The Member-Secretary,
Chennai Metropolitan
Development Authority,
No.8, Gandhi Irwin Road,
CHENNAI -600 008

Letter No. **B2/6158/2000**

Dated: **27-04-2000**

Sub: CMDA - Area Plans Unit - Planning Permission
proposed construction of GF+3Floors residential
buildings with 12 Dwelling Units at T.S.No.34/1
and 34/2, Block No.40 of Puliyur Village in
Door No.28, Outer Circular Road, United India
Colony, Kodambakkam, Chennai-21 - Development
Charge advice sent - Regarding.

SITE PLAN
 (SCALE 1:200)

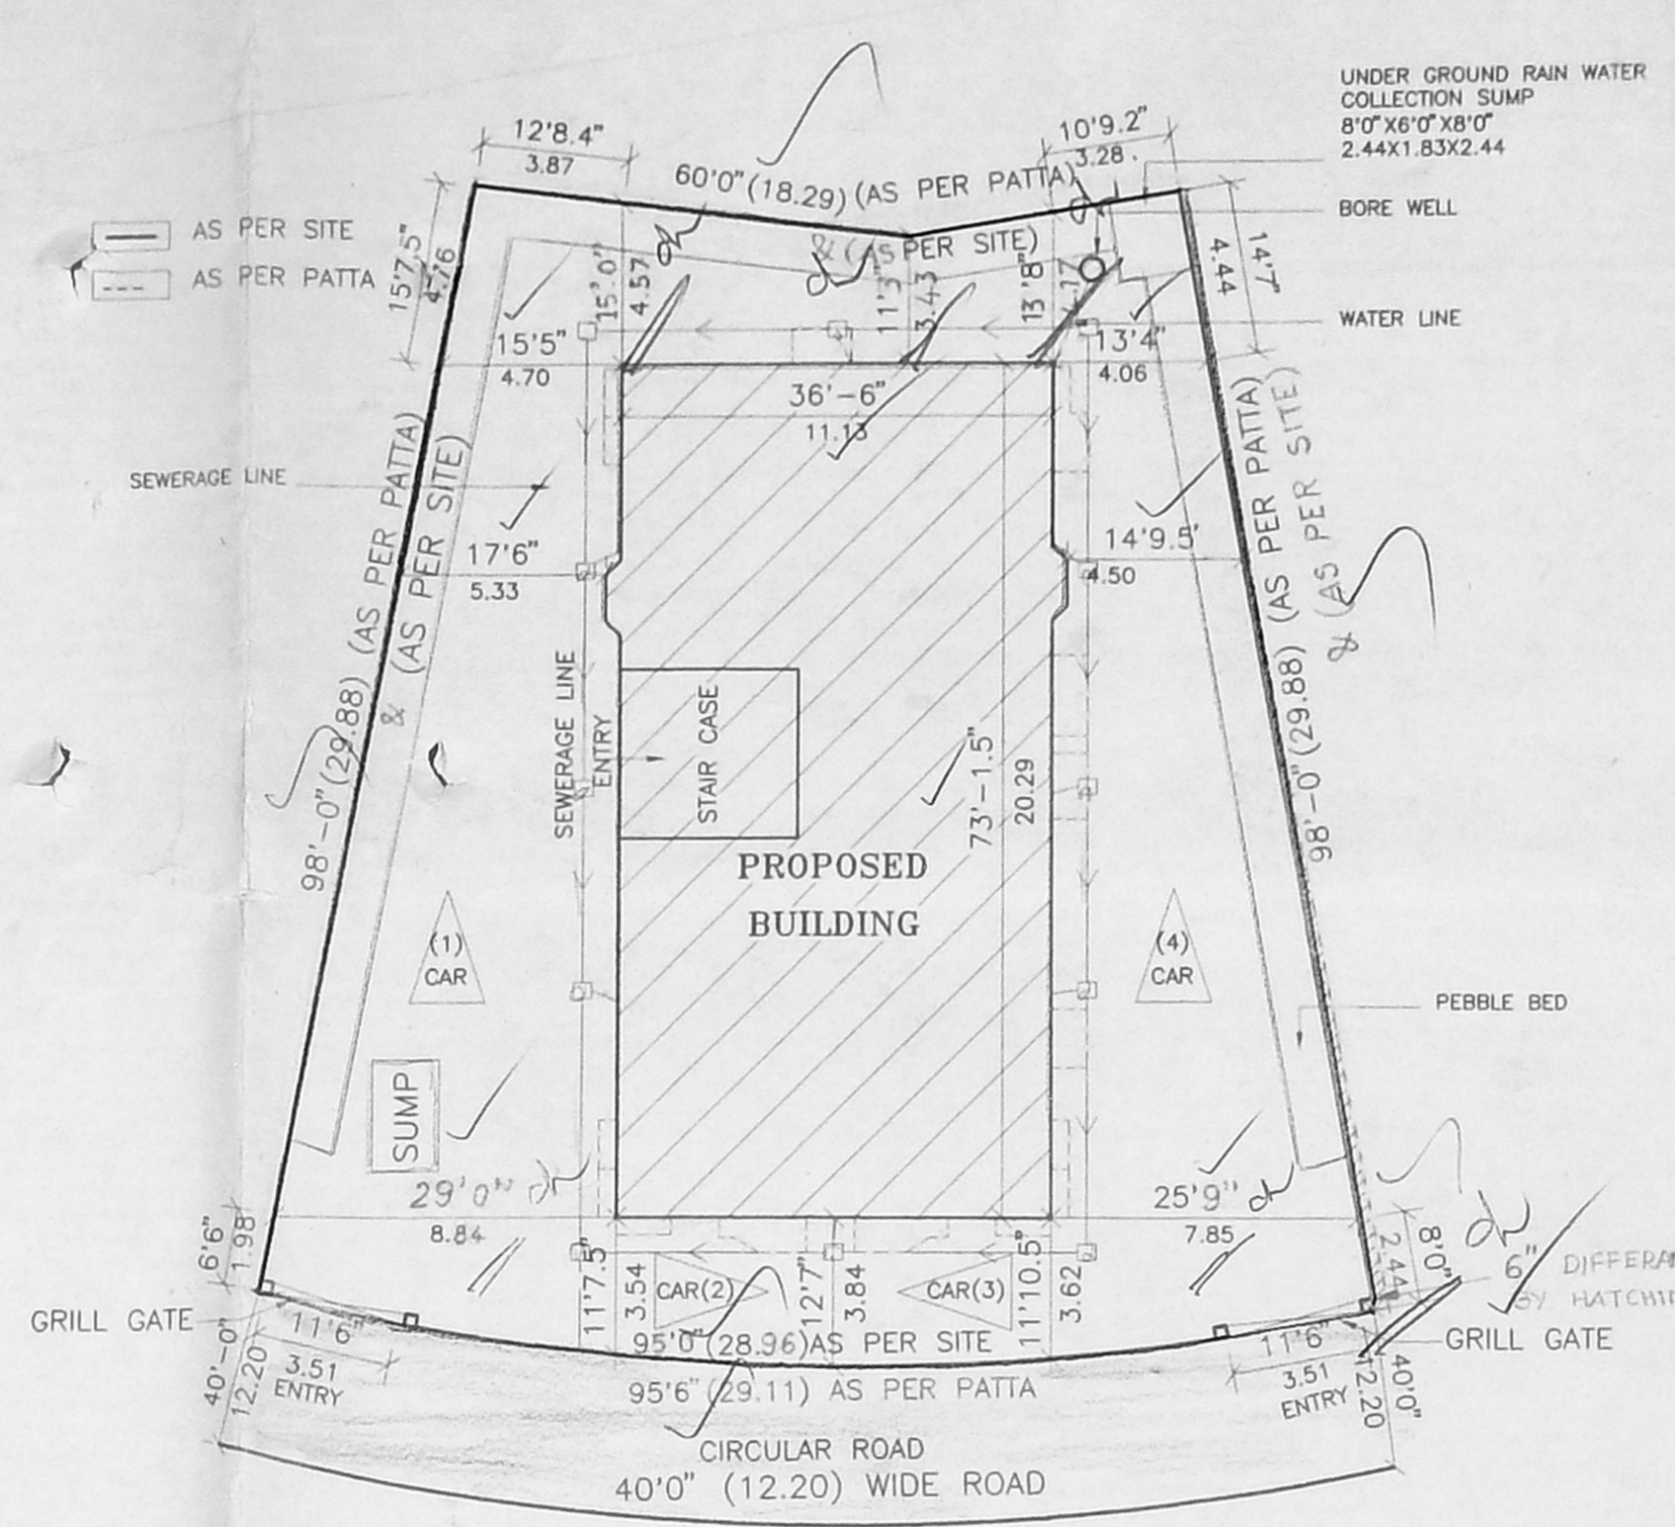
- a) Revised site plan showing the boundary measurements. as per PLR and ~~xxxxxx~~ as well as, as per as on site condition and distinguish the difference by hatching and to provide required set back from the minimum dimension line.
 - b) Revised re-constitution deed in Rs.22.50/- stamped paper as per the spe cified format, duly notarised in all the ~~xxxxxx~~ pages.
 - c) Owner's undertaking deed duly notarised in all the pages.
- ~~*) Revised Corporation of Chennai's existing plan incorporating all the structures existing in the site under reference~~
